Re: BusConnects Lucan to City Centre Core Bus Corridor Scheme
Lucan to Dublin City Centre

OBSERVATION IN RELATION TO
LANDS AT KNOCKMAREE, ST. LAURENCE'S ROAD,
CHAPELIZOD, DUBLIN 20

LUCAN TO CITY CENTRE CORE BUS CORRIDOR SCHEME
COMPULSORY PURCHASE ORDER 2022

PLOT REFERENCE NO. : 1023(1).1f & 1023(2).2f

Drawing File Name: BCIDA-ACM-ENV_LA-0006_XX_00-DR-LL-0020 | Sheet Number: 20 of 31 | Status: A | Rev: M01

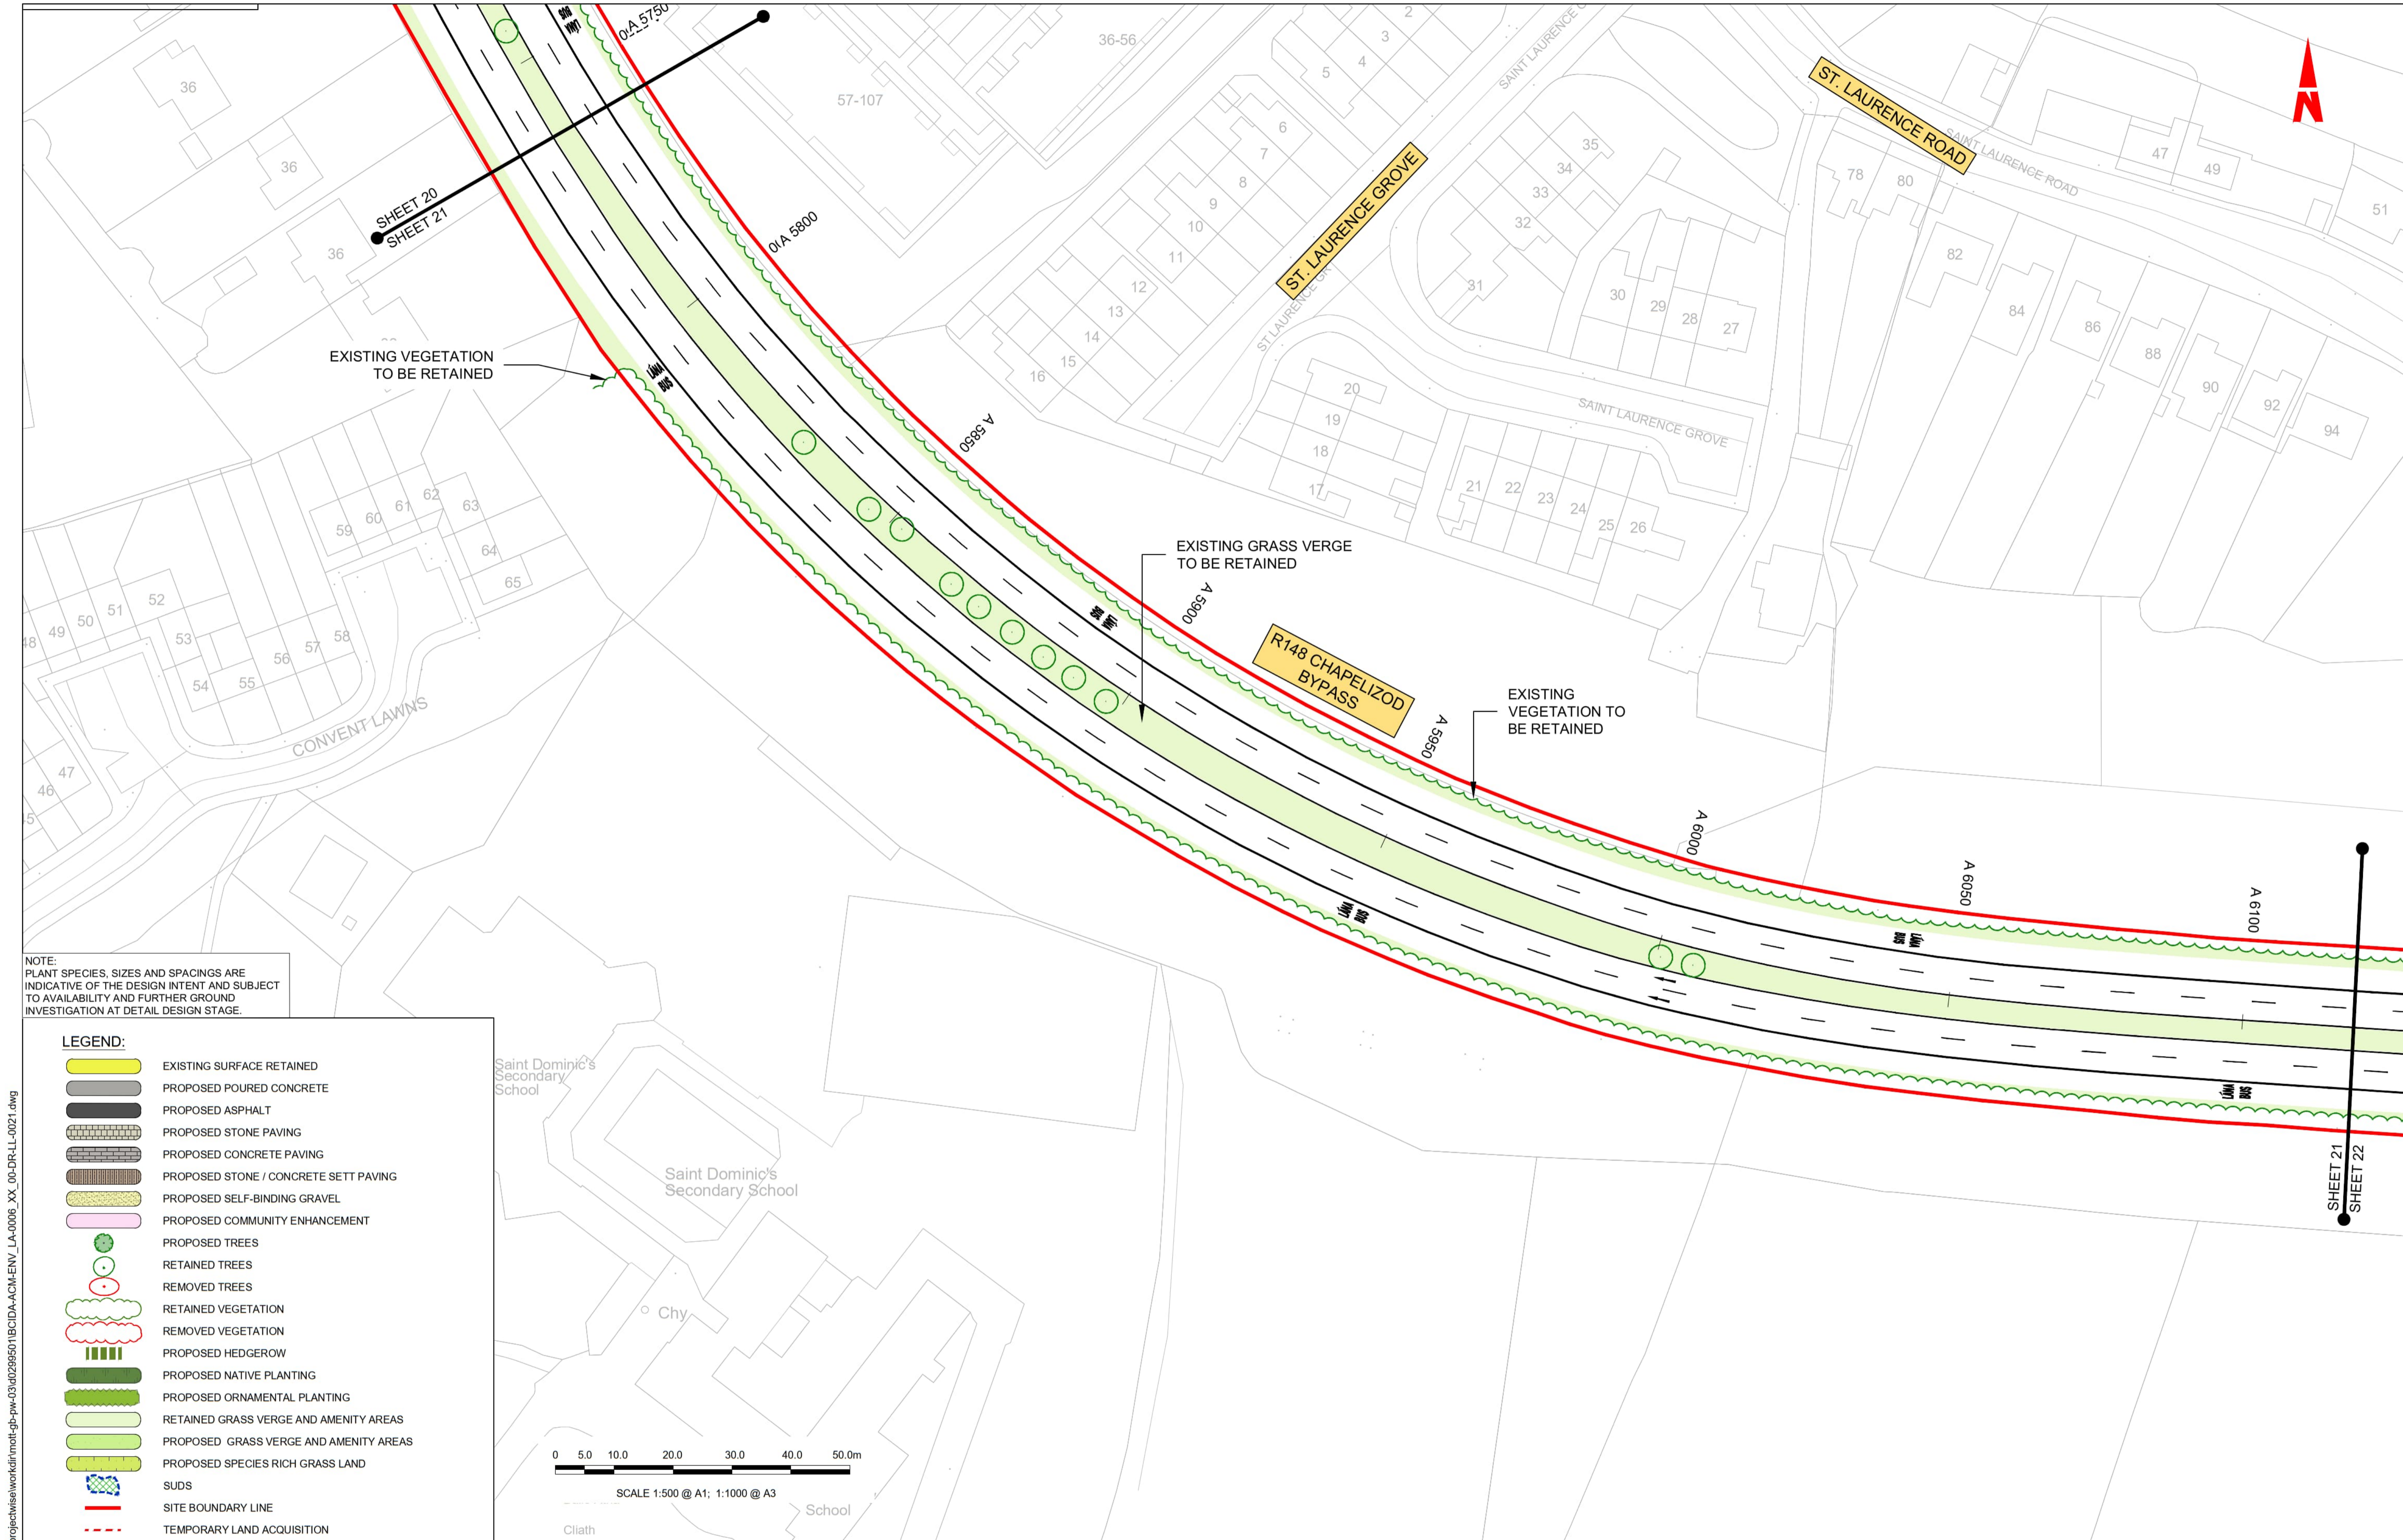
3.6 The drawing (Drawing no. DR-LL-0020 (Sheet 20 of 31) does not adequately indicate the tree cover on the steeply sloping lands, and the extent of the tree cover that will be lost. Assuming that all trees will also be removed within Temporary CPO lands, to facilitate the heavy engineered ground works and supporting structure proposed, we have estimated that all bar the lowest trees will be lost. This is based on a retaining structure being required within a few metres of the substation, and the Temporary CPO extending a corridor around these works to facilitate them. This will have a profound negative impact on the visual amenity and feeling of privacy within Knockmaree.

3.7 There are no details within the Arboricultural Impact Assessment that forms Appendix A17.1 of the EIAR, on the species, quality, condition, spread or maturity of these trees, and therefore their categorisation has not been adequately considered within the EIAR. We respectfully submit that the conclusions of the Arboricultural Impact Assessment within the EIAR are therefore deeply flawed. The hard nature of the works and removal of green infrastructure will also have a significant negative impact on the biodiversity of the area. It is also our understanding that a number of services and utilities run beneath the ground adjacent to the boundary with Knockmaree that will be impacted, and will need to be relocated by the proposed development. Any loss of any service or utilities during the construction works will be unacceptable to the residents of Knockmaree.
